Homebush Bay Bridge | Environmental Assessment

## APPENDIX E

Government authorities  
and public utility providers  
consultation meeting minutes  
and correspondence

**ISSUES IDENTIFIED BY CITY OF CANADA BAY, RELATING TO THE  
HOMEBUSH BAY BRIDGE**

ARTIST IMPRESSION OF POTENTIAL OPEN SPACE TREATMENTS AND RELATIONSHIP WITH PROPOSED BRIDGE AND ITS LANDING AT RHODES.

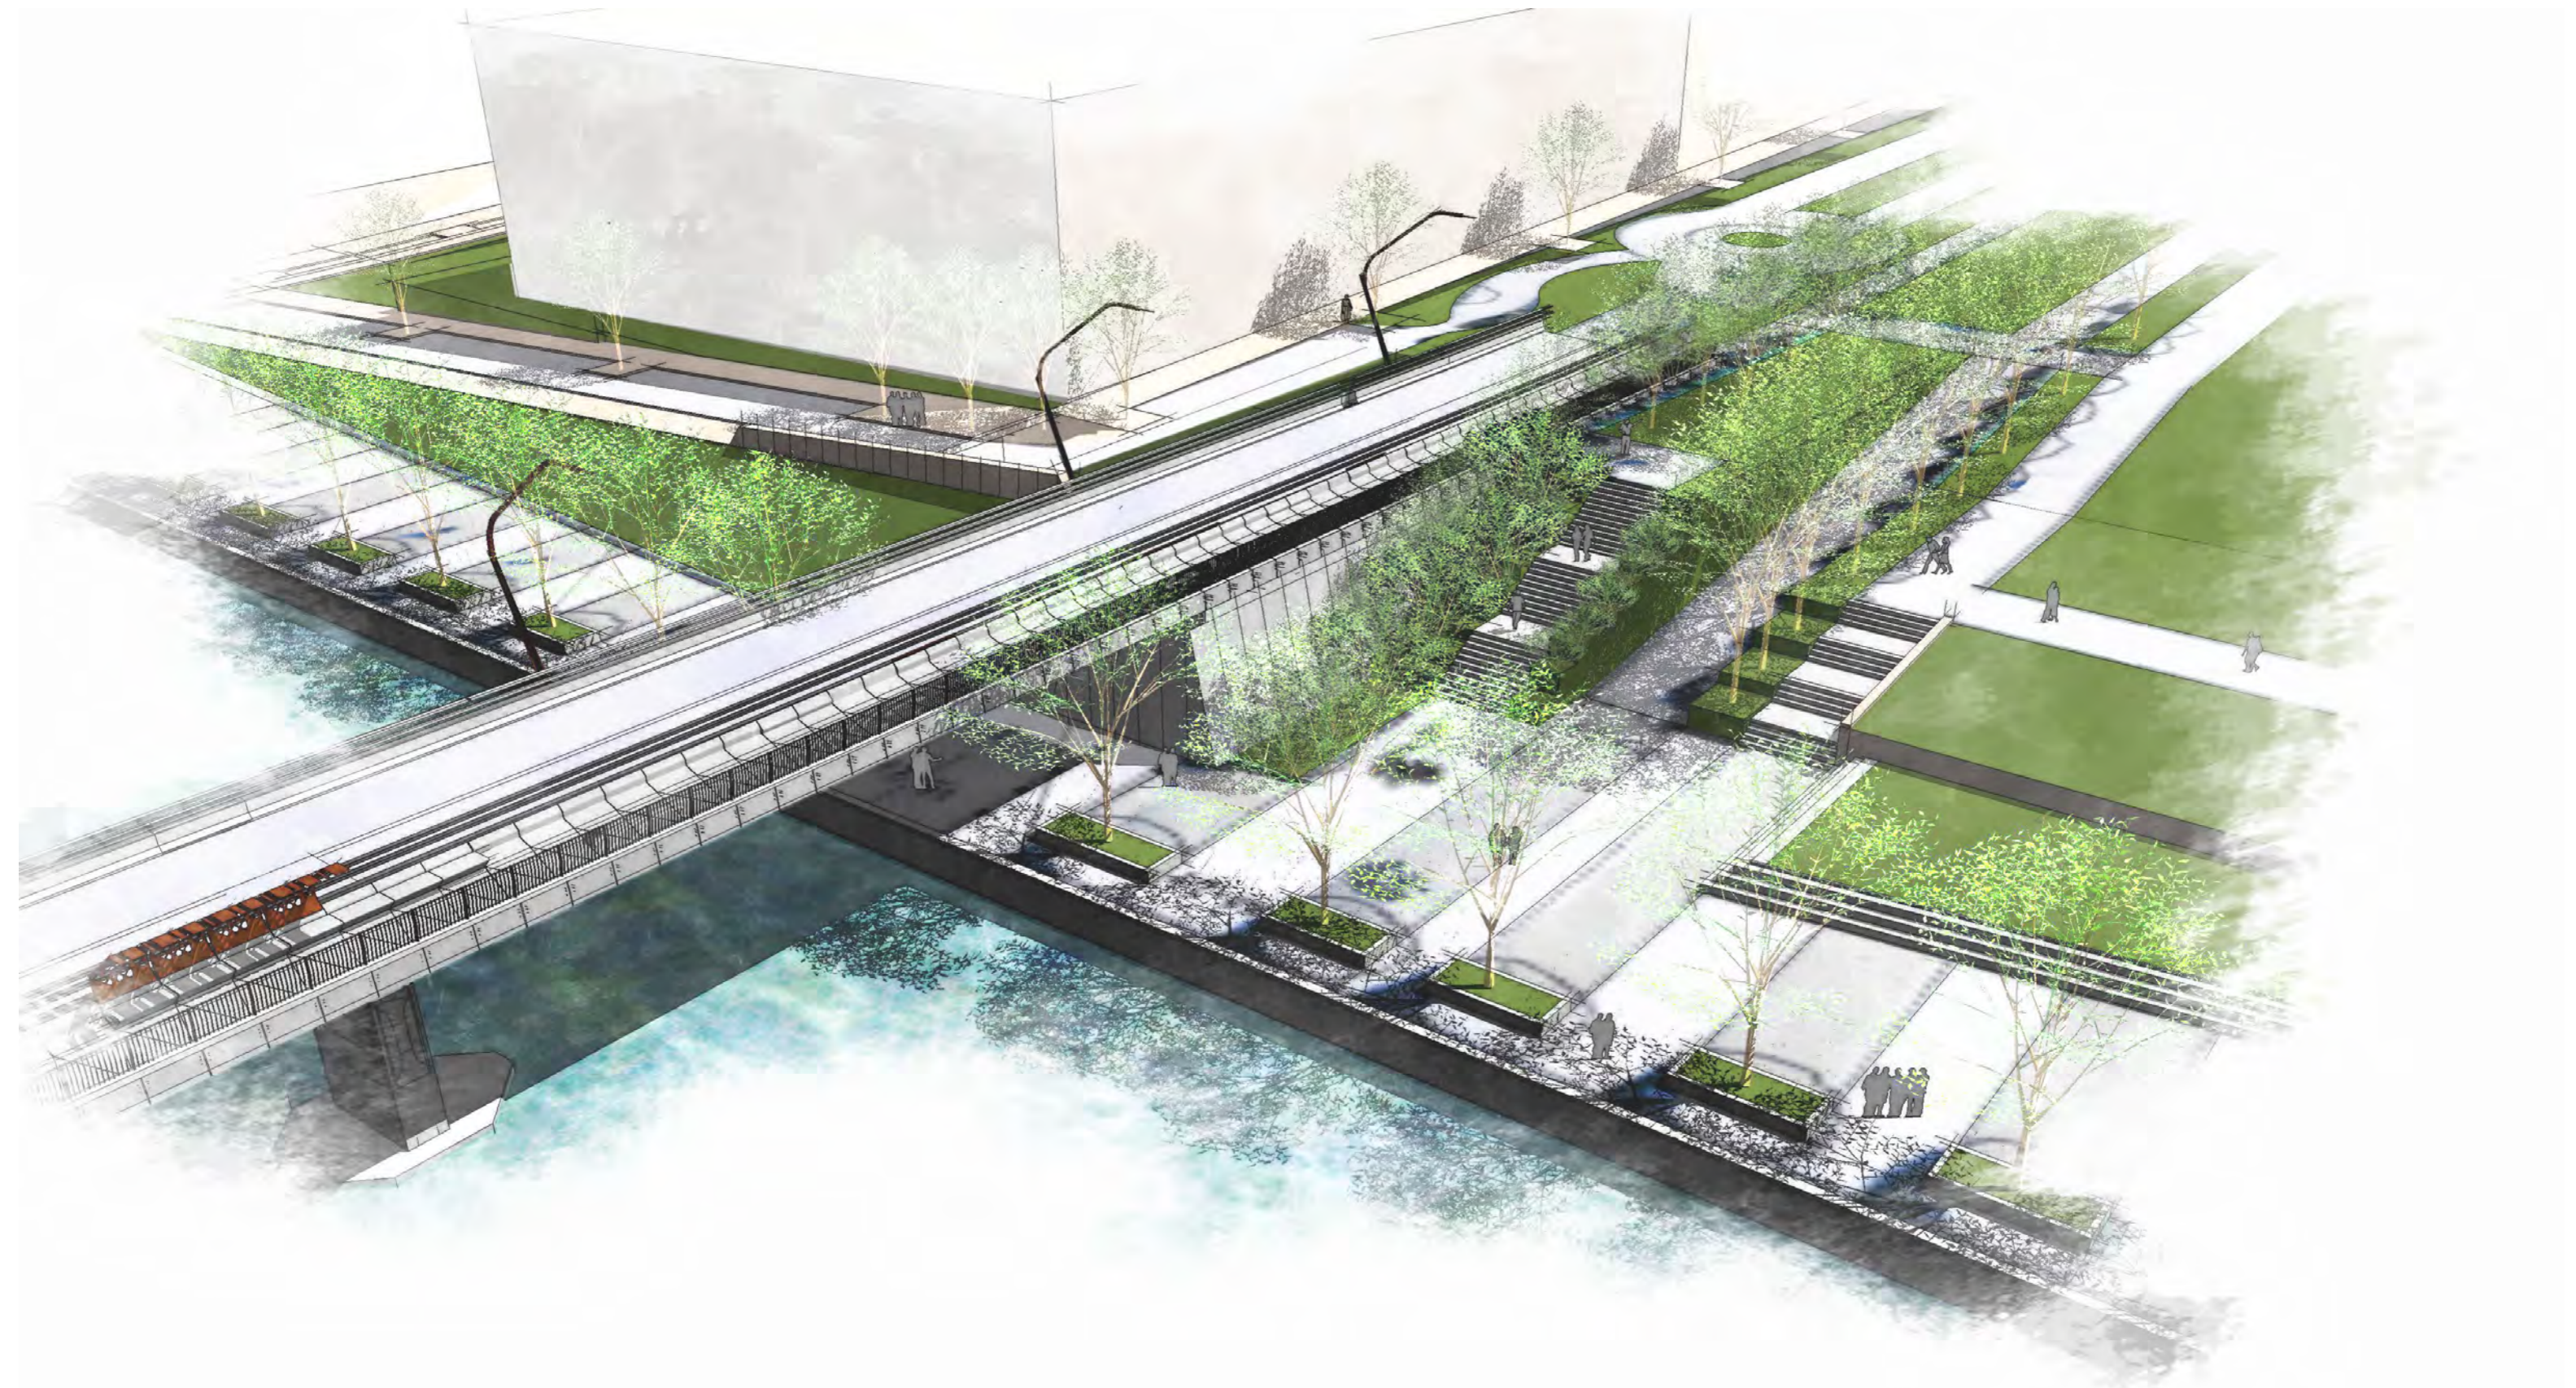
- Council would like its Community Centre and forecourt area to be the focal point of the Rhodes Foreshore, and not the proposed Bridge abutment. This should be reflected in the urban design and landscape treatments of all areas around the Bridge landing.
- The Community Centre floor level will be the Probably Maximum Flood (PMF) flood level plus 500 mm freeboard. The Community Centre will have two levels.

- Council accepts that the Bridge will require a construction and landing compound which will be landscaped area shown in the Bridge Landing Concept Rhodes (June 2011)

- Council would expect the developer to raise and strengthen the seawall at the abutment and the ramps to accommodate the Bridge levels. This will ensure that Council will not have to fund bridge abutment protection measures in the future, arising from sea level rise due to climate change.
- The Bridge abutment shall be immediately behind the seawall to minimise the Bridge's occupation of the Foreshore Park and Community Centre forecourt. This will allow Council's Foreshore Park and Community Centre forecourt to be designed without the constraint of the Bridge abutment, terminals, fencing and traffic barrier rails.

- The consultant team fully understands that Council would like its Community Centre and forecourt area to be the focal point of the Rhodes Foreshore, and not the proposed Bridge abutment. The team would like to stress that the illustrative sketches presented at our meetings have been produced simply to identify issues that need to be addressed when the foreshore area is being designed. However, this design task is not the responsibility of the Bridge designers – rather, when Council's design for this area is being prepared, the Bridge approach lanes through the park need to be considered and should be reflected in the urban design and landscape treatments of all areas around the Bridge landing.

- Council's comments regarding disabled ramps, adjusting levels and strengthening seawalls and undertaking landscaping are based on a misunderstanding of the sketches and diagrams of the landing (June 2011). These plans were prepared simply to illustrate issues rather than to propose a solution. As Council and the developer have agreed to collaborate on the preparation of the respective designs of adjoining areas, these interface works will be eliminated. The plan now attached illustrates the potential Bridge landing zone within which the Bridge termination may occur in order to coordinate with Council's preferred levels.
